Consultee Comment for planning application 6/2021/3422/MAJ

| Location | Salisbury Square Hatfield AL9 5AD |
| Proposal | Erection of 1 x building containing 3 x flats, 11 x offices and 1 x retail unit (Use Class E), erection of 5 x terrace houses with parking and associated works, involving demolition of existing shopping parade with 7 x maisonettes above, alterations to existing parking area and erection of a parking area |
| Organisation | Hertfordshire Constabulary |

CLIENT: GASCOYNE ESTATES  
JOB: SALISBURY SQUARE HATFIELD AL9 5AD  
DRAWING TITLE: PROPOSED FIRST, SECOND AND ROOF PLANS  
SCALE: 1:100 A1 / 1:200@A3  
DATE: NOVEMBER 2021  
STATUS: PLANNING  
DRAWING NUMBER: 789 - PL - 151 REV: B ISSUED BY: FF

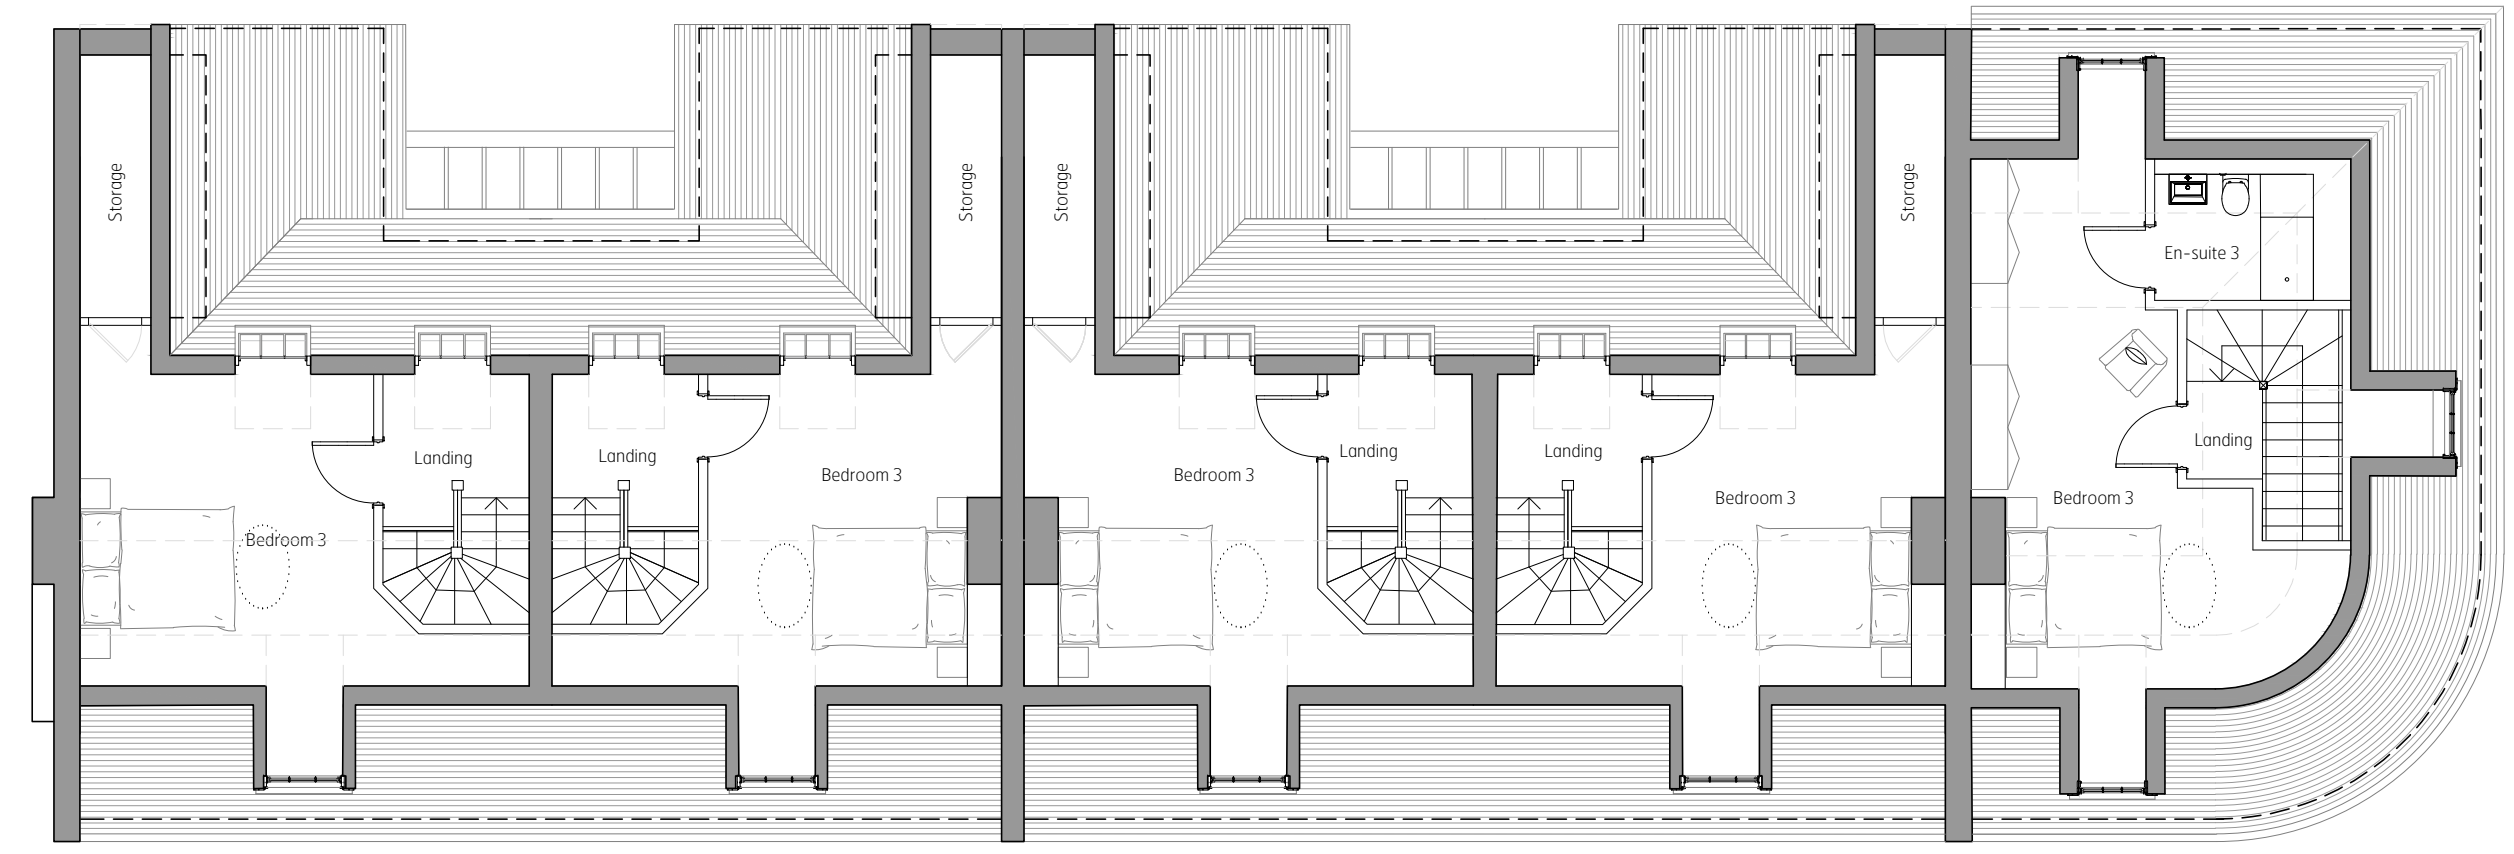
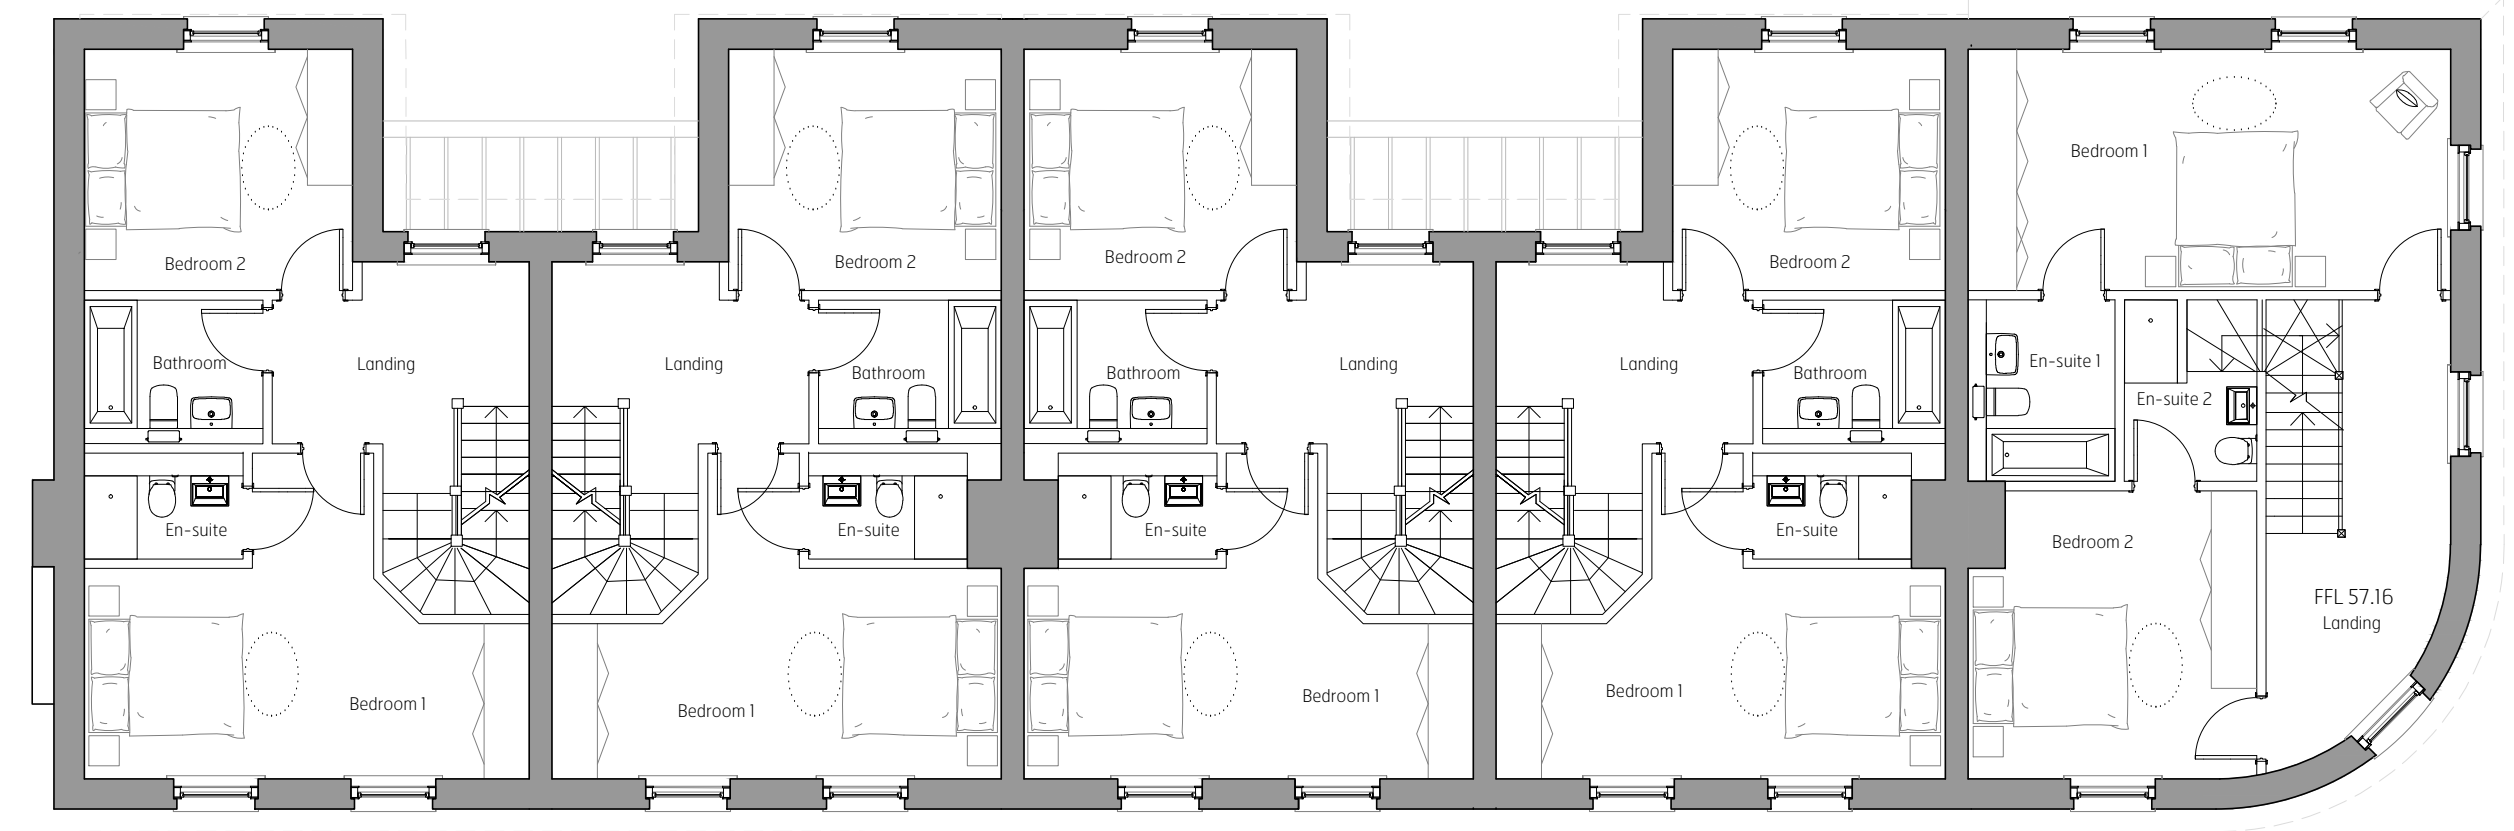
| Comments | <p>The rears of the 5 town house properties must be protected due to the exposed nature of the area. Nos 64 and 65 particularly so as they are within a communal area on the corner of the block. Key lockable gates must be fitted. All entrance doors along with all ground floor windows must be compliant with PAS24 as required by BR 99 however, I would recommend that the improved 2016. version be used rather than the out-of-date 2012. version referred to in the regulation. Given the number of doors required, they should not be classed as bespoke, rather correctly rated wooden doors should be sourced. I would expect to see some low lux level lighting to the front of the building to allow users to both see and be seen. Likewise, the widely dispersed car parking areas will need some low-level illumination from wall or column mounted luminaires (not bollards). From a crime prevention perspective, I would only be able to support this application should the above matters be addressed.</p> |
